28th June 2022

Town & Country Planning Act 1990 (as amended)
Town and Country Planning (Development Management Procedure) (England) Order 2015

Application No: BN/65/22/PL
Site Address: Land at rear of Cedar End Eastergate Lane Eastergate PO20 3SJ
Description of works: Sever land and erection of 1 No bungalow with new vehicular access (resubmission of BN/14/22/PL). This application is a Departure from the Development Plan and is in CIL Zone 3 and is CIL Liable as new dwelling.

Proposed Site Plan
1:200

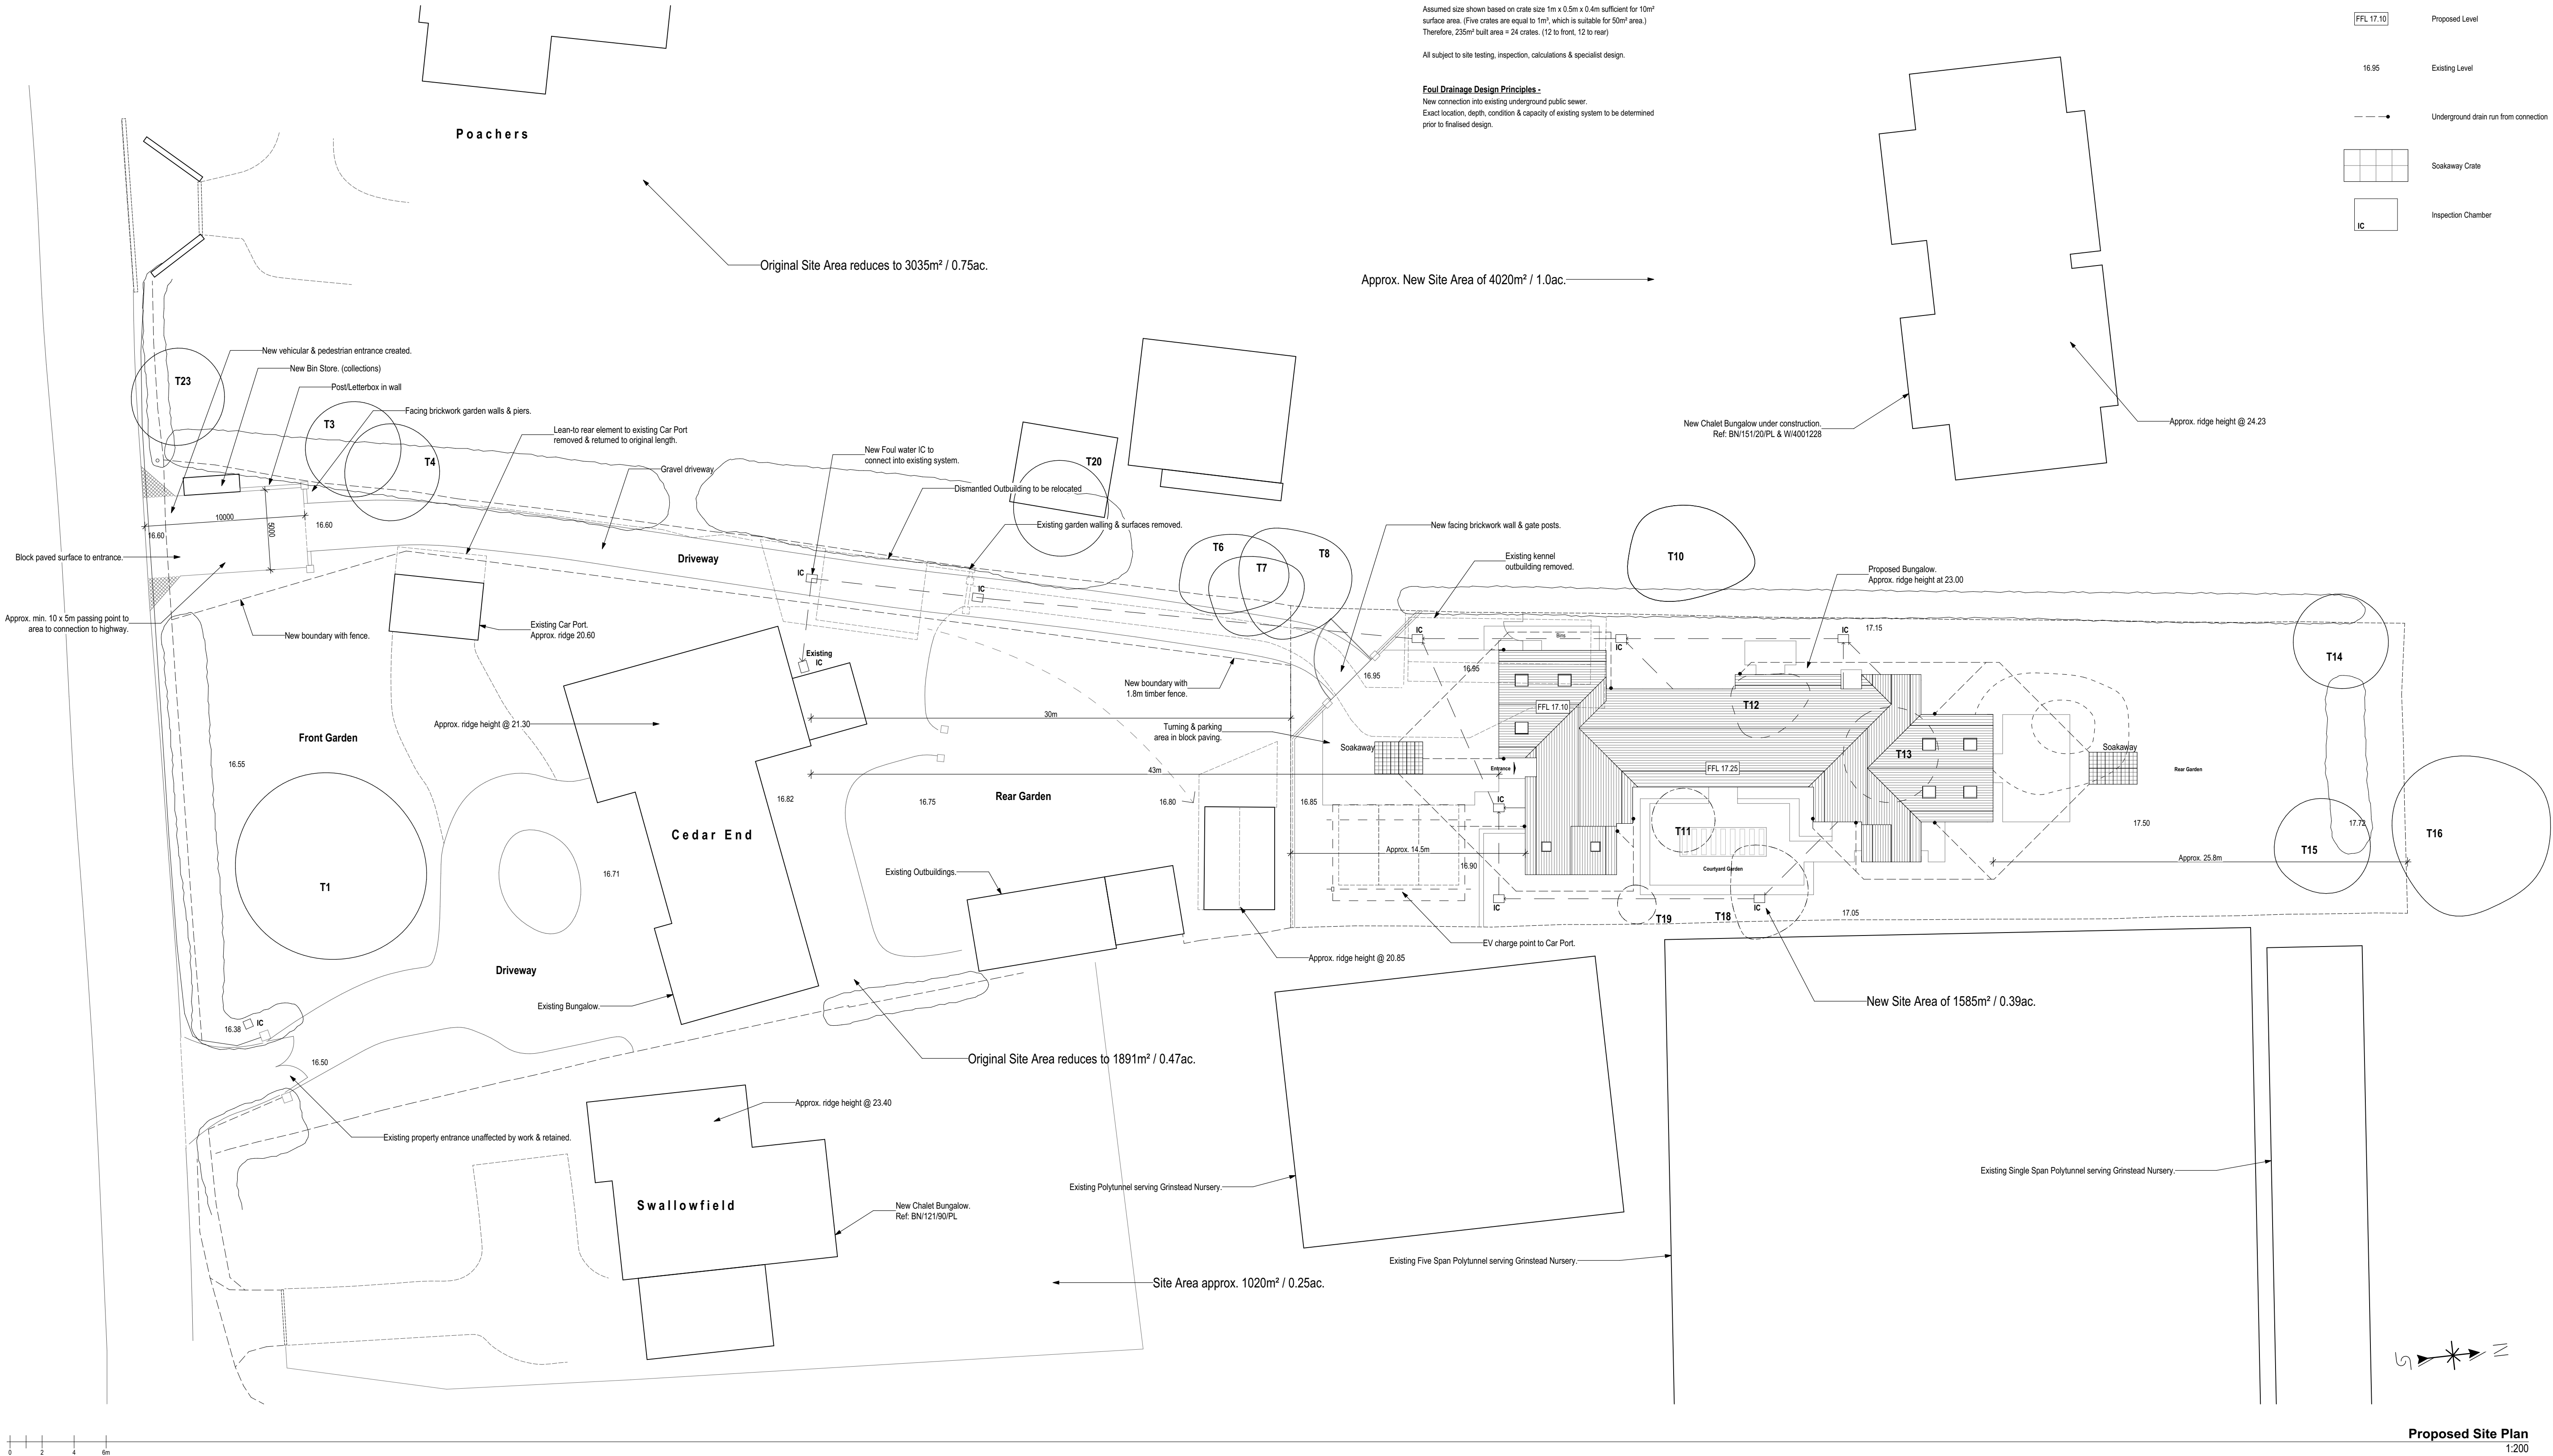
The Site Plan presented as 1671-SYM-00-ZZ-DR-A-0200 P01 Rev 01 (although the number on the actual plan is only 1671-SYM-00-ZZ-DR-A-0200 P01) does not show the existing accesses to Eastergate Lane from my property, Bennetts/Dundarg. One of these is directly opposite the new access proposed by the applicant.

No scale visibility splay plan is included in the application. From Plan 1671-SYM-00-ZZ-DR-A-0200 P01 it is difficult to see how legal splay requirements could be met without removal of a large part of the existing hedge bordering the road and possibly Easterly neighbours vegetation/fencing as well. This would be detrimental to the character of local surroundings even if possible without affecting neighbouring property.
